Rezoning Transportation Analysis

Petition Number: 2023-067

Date	Description
8-24-23	First Review (NK)

TECHNICAL DATA SHEET

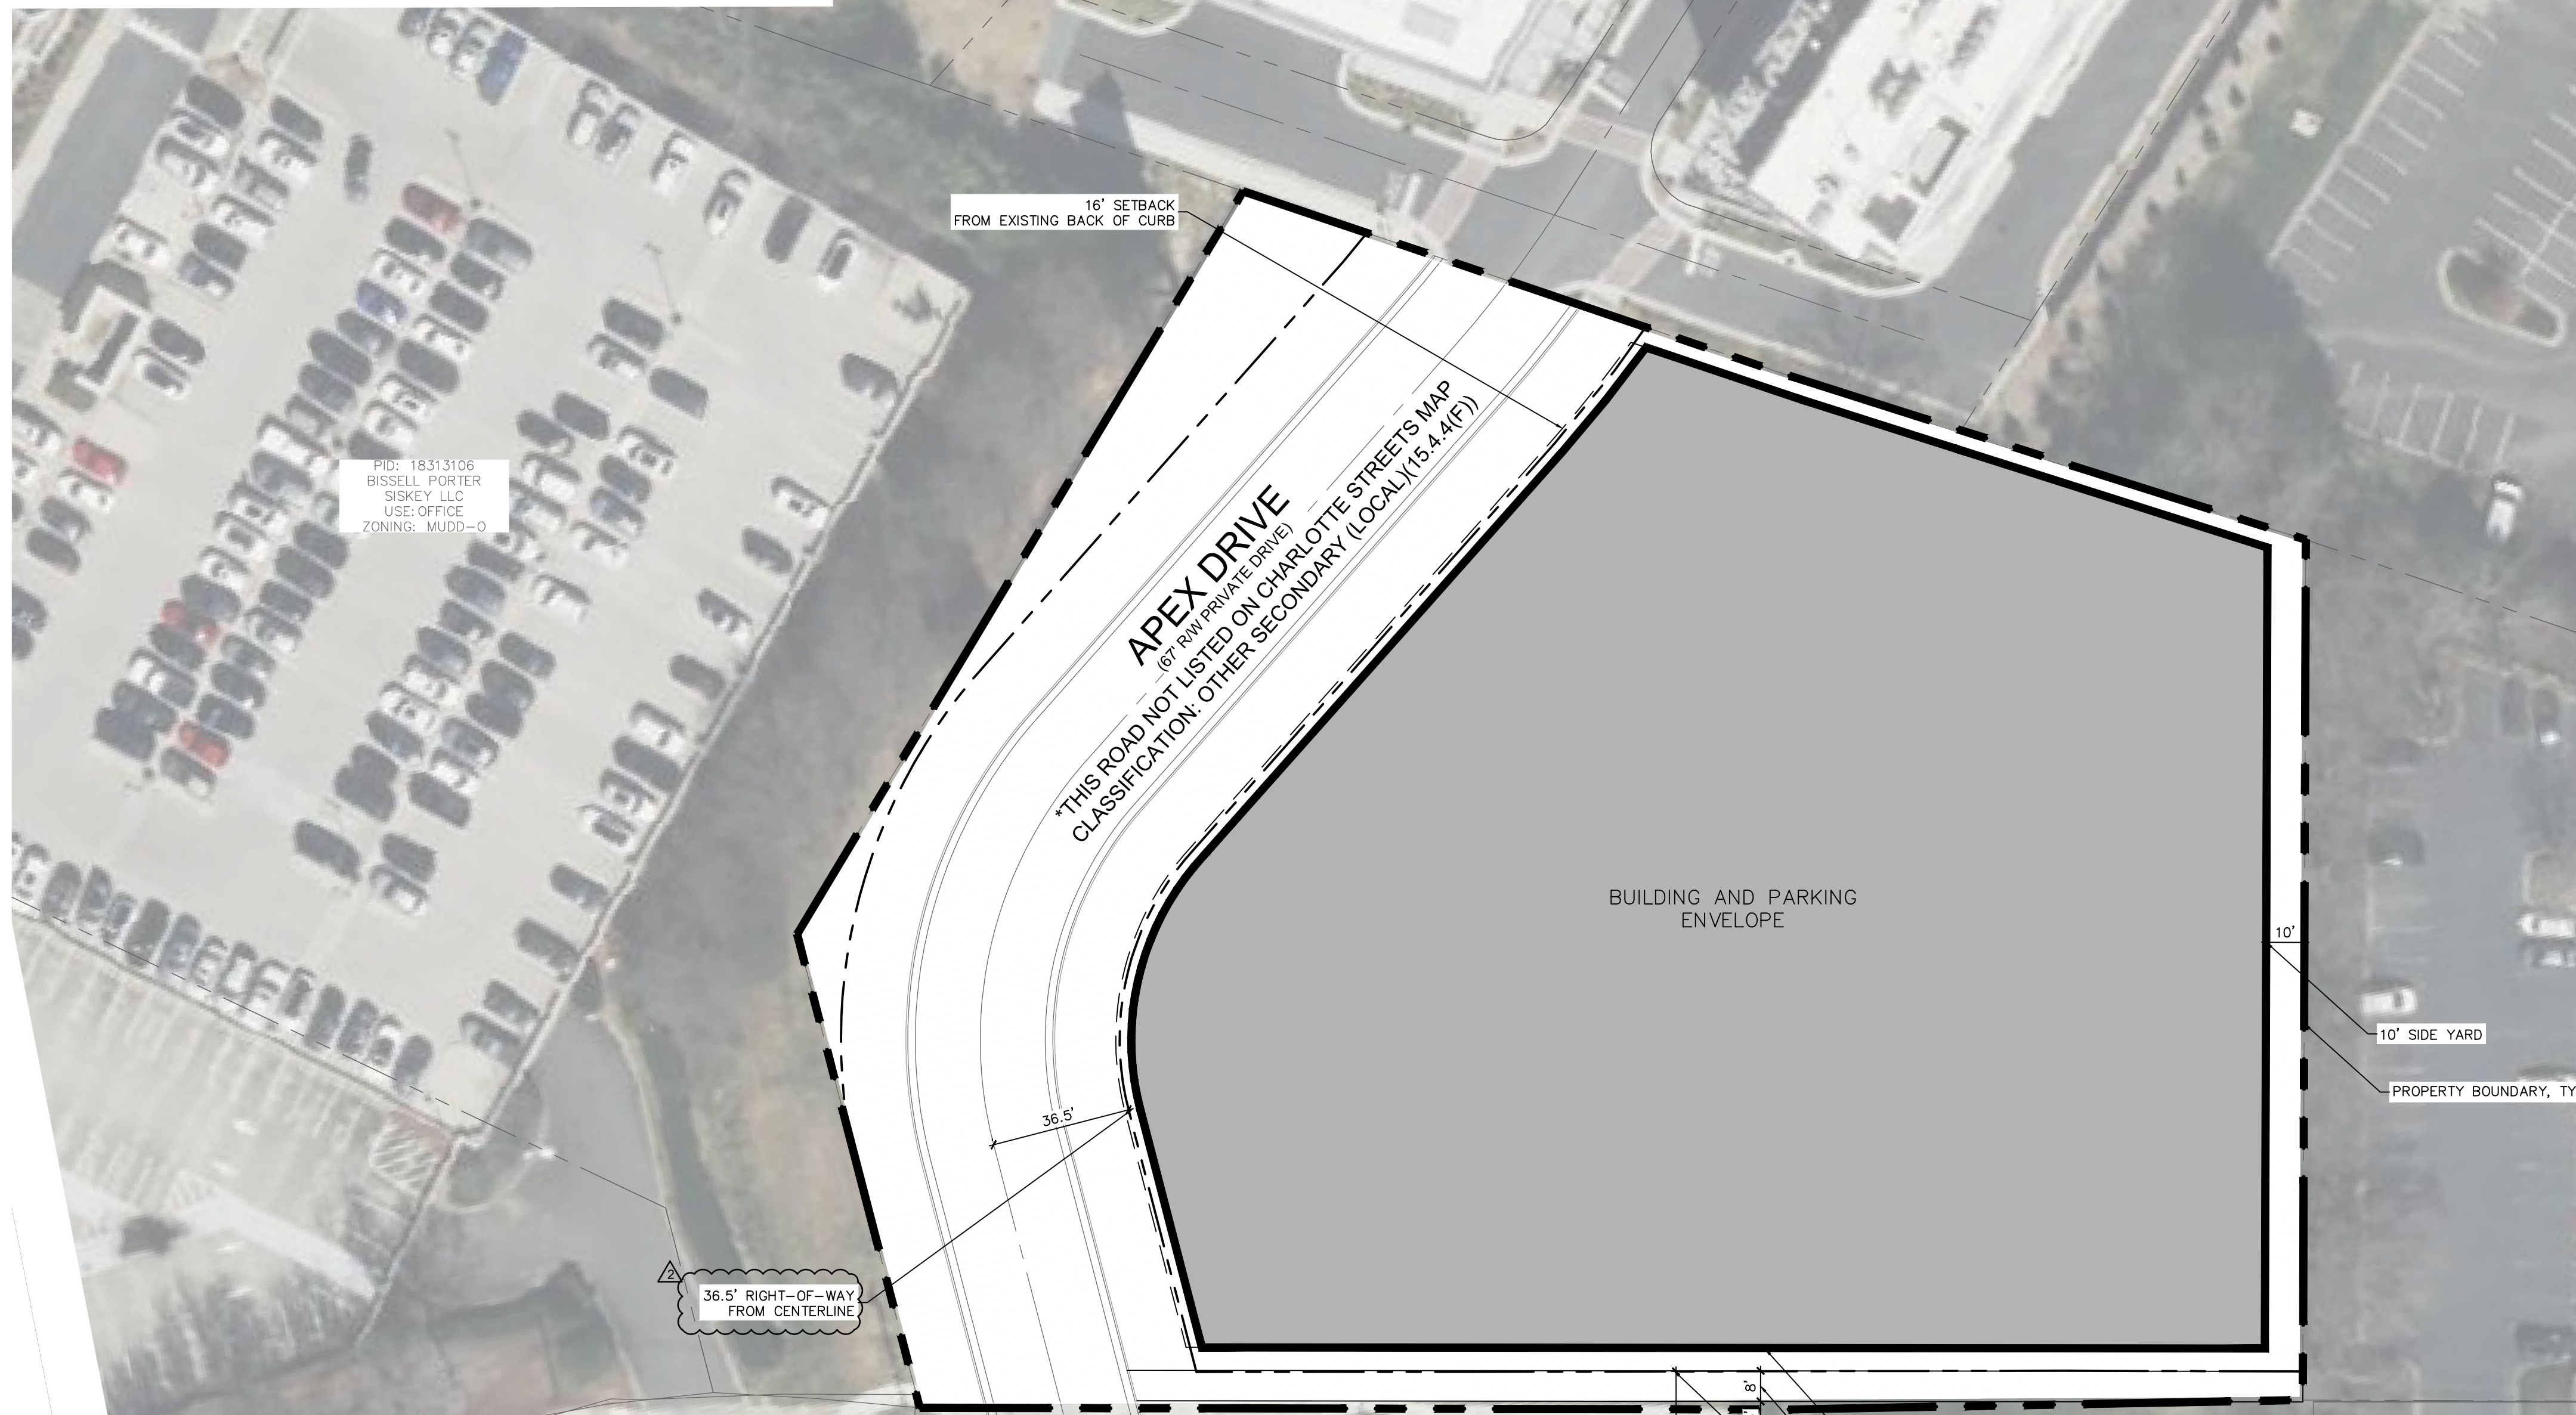
1. Curblines:

Coltsgate Road Future back of curb is in its existing location.

Label and dimension the curb and gutter from the centerline for each road on the site plan.

3. Revise site plan and conditional note(s) to commit to dedicate 36' 6" right-of-way from the road centerline. The site plan shall label and dimension the right-of-way from the road centerline.
